**Highways England: A303 Amesbury to Berwick
Down Project, Development Consent Order
Application**

Scheme Reference: TR010025

**Response to Highways England's Document
"8.44 - Comments on any further information
requested by the ExA and received at Deadline 5
and 6" (REP 7-021)**

**The Stonehenge Alliance
(Reference No. 2001870)**

Figure 2 Chalk Stratigraphy with Tunnel and Chalk Rock Elevations (adapted from Mortimore (2012))

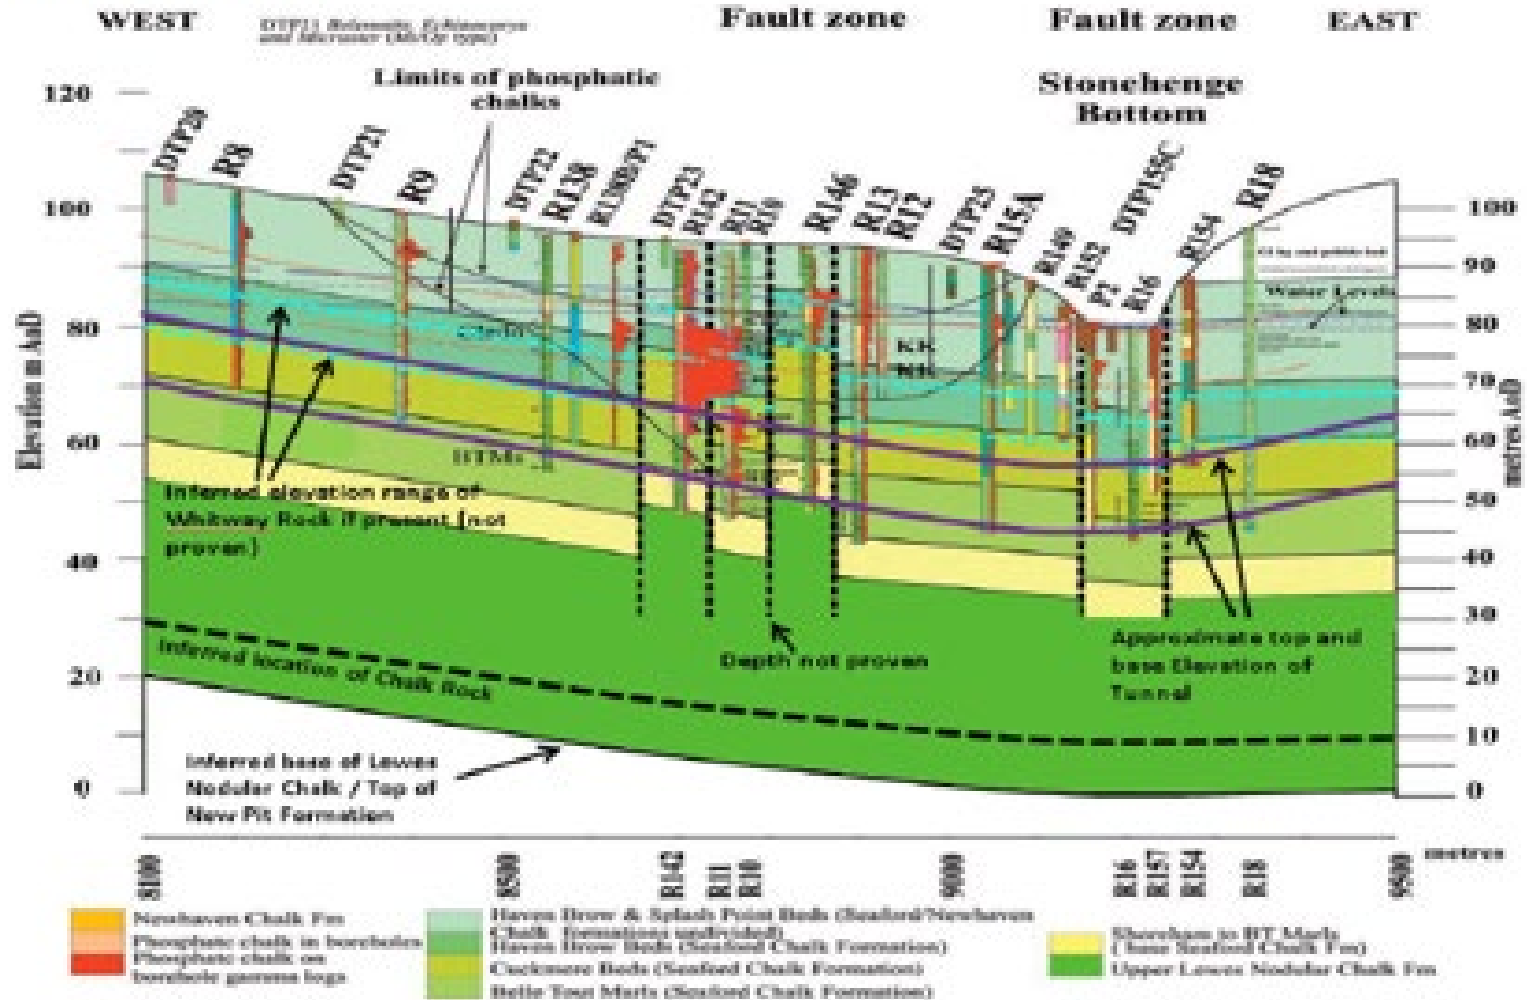
The Alliance maintains its position as set out. Please see also the slides and presentation notes by Dr Reeves prepared for ISH 10. Dr Reeves' current opinion is that Whitway Rock is present but not fully identified and that it could have a profound impact on groundwater movement in tunnelling.

"[REP3-018] Figure 2 shows the stratigraphic position of the Whitway Rock if it were present in the area. It would be situated largely above the tunnel profile and therefore would not have a

significantly different effect on groundwater levels compared to the effects described in the Groundwater Risk Assessment [APP-282]. See also the Environment Agency response to the potential presence and location of the Whitway Rock in REP4-049, paragraph 1.2.3, which recognises that this unit has not been mapped in the area and if present is expected to be above the tunnel elevation.”

The Stonehenge Alliance suggests there is evidence to show that the Whitway Rock horizon is present and not entirely above the tunnel elevation: this could substantially change the situation as given by Highways England. Clarity on this issue is vital to the viability of the Scheme and to those areas affected by groundwater movement.
